From: MARK CHISHOLM <[REDACTED]>
Sent: 14 October 2019 11:15
To: Zac Denton <[REDACTED]>
Cc: Mark Ramuz <[REDACTED]>
Subject: Re: M/73/19/HH - 7 Sea Way, East Preston

This email is regarding the application for the erection of a single storey outbuilding at the above application site.

Garden studio & washroom

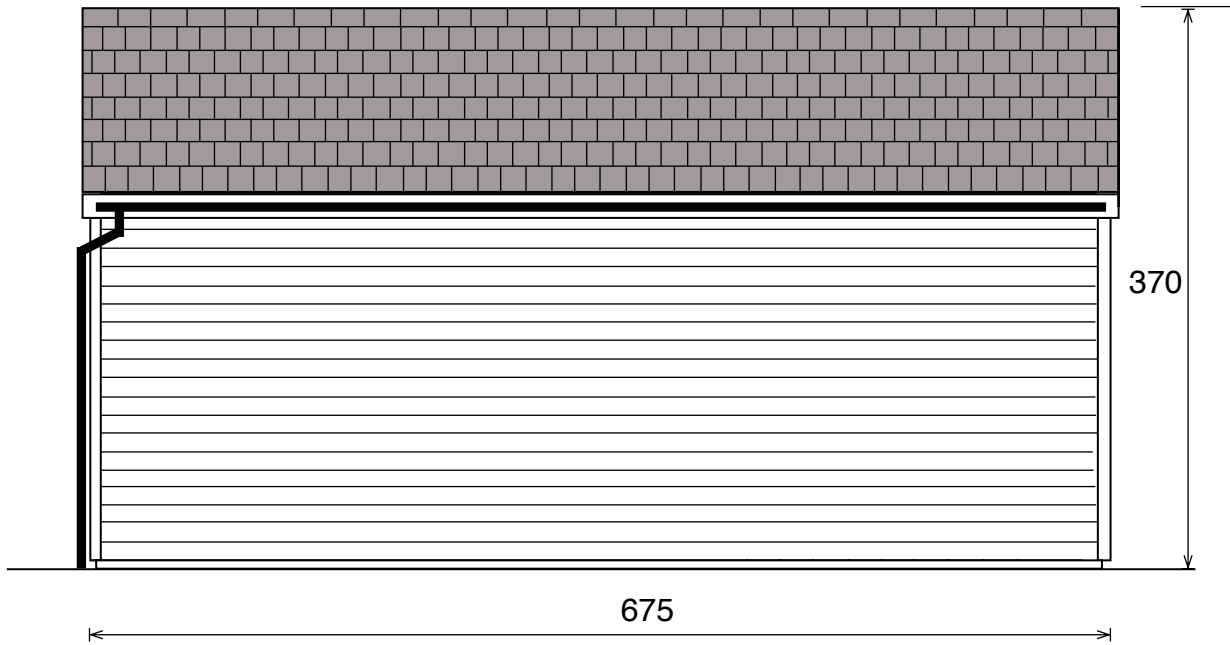
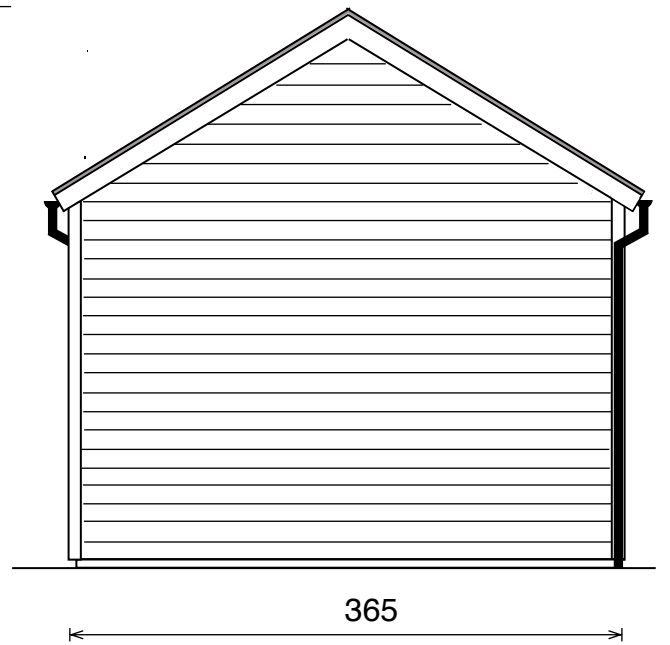
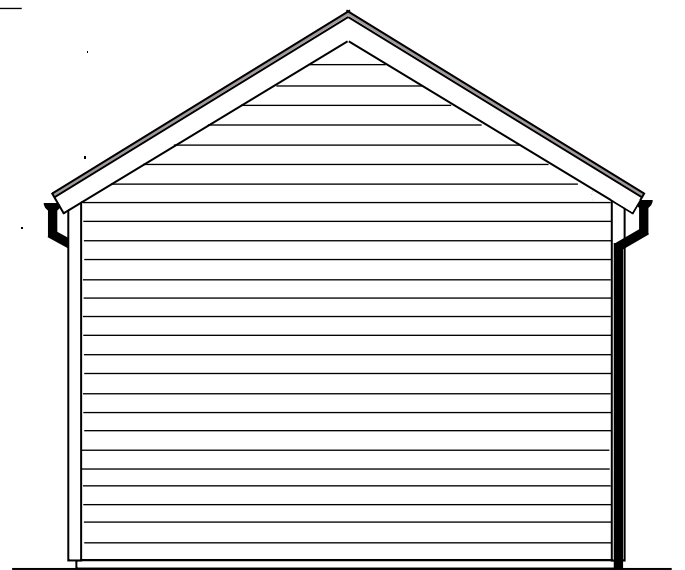
As it stands, the application is not looked upon favourably, as a result of its scale allowing for there to be views of the proposal from the street scene. The proposal is considered to be ugly and unattractive due to its proposed materials.

I am emailing to ask if you would consider altering the proposed materials, as it is felt that more sympathetic materials may remove the current issues with the proposal.

Hi Zac, following our conversation this morning, I've attached a revised scale drawing showing a slate roof rather than sheet steel. I understand that this will now be put out for consultation. Could you estimate when a revised decision date will be?
